Reference: Septic System Design Modification
Victoria Hills II – Lot 61

Lot 61, Victoria Hills Phase 7

On-Site Wastewater Design Specifications

Lot 61, Victoria Hills Phase 7

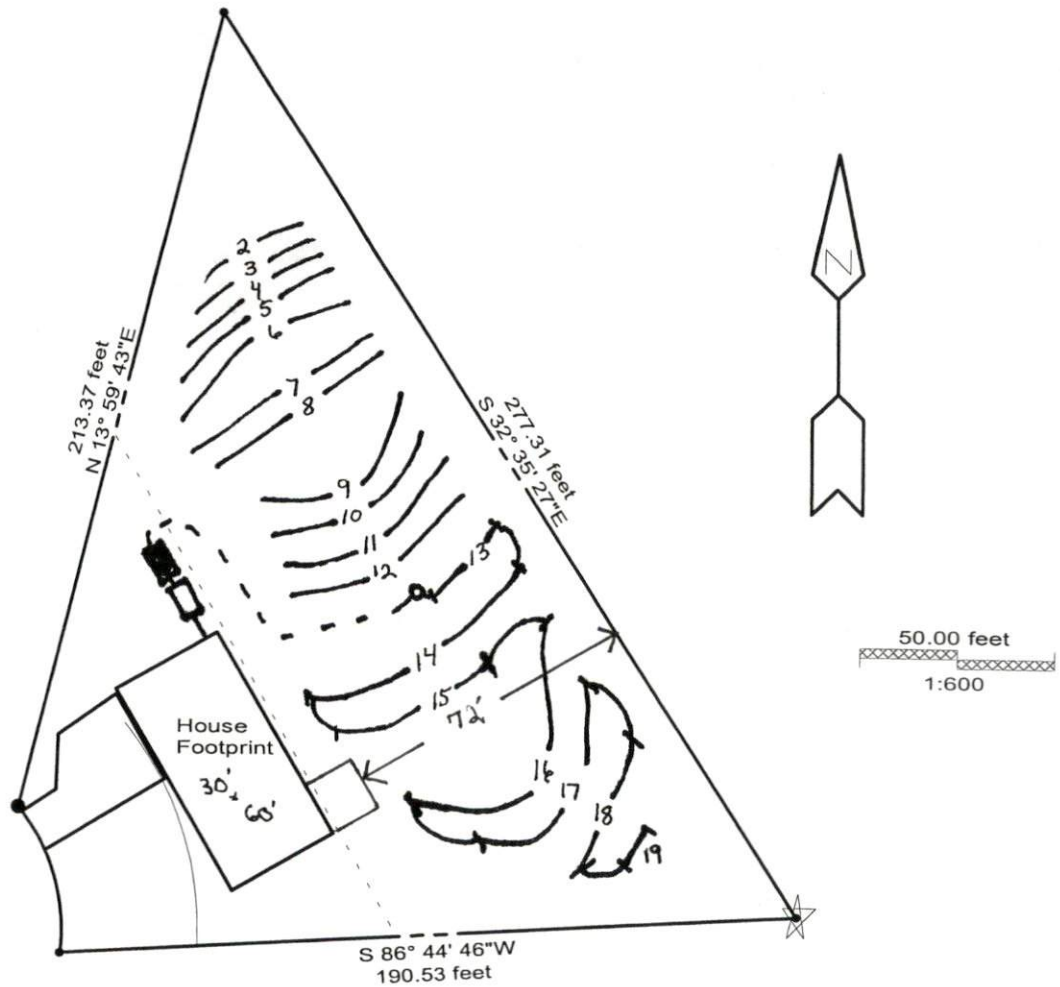
Enclosed are the septic system design revisions for the above referenced property that we had discussed at our site meeting on 2 February 2005. The new proposed initial septic system utilizes a pump to serial distribution of 300 linear feet of innovative drainlines. The repair septic system remains unaltered from the original proposal that consisted of a low-pressure pipe distribution system with a pretreatment filter because of limited depths to unsuitable layers within the 12-inch treatment zone below the trench bottom.
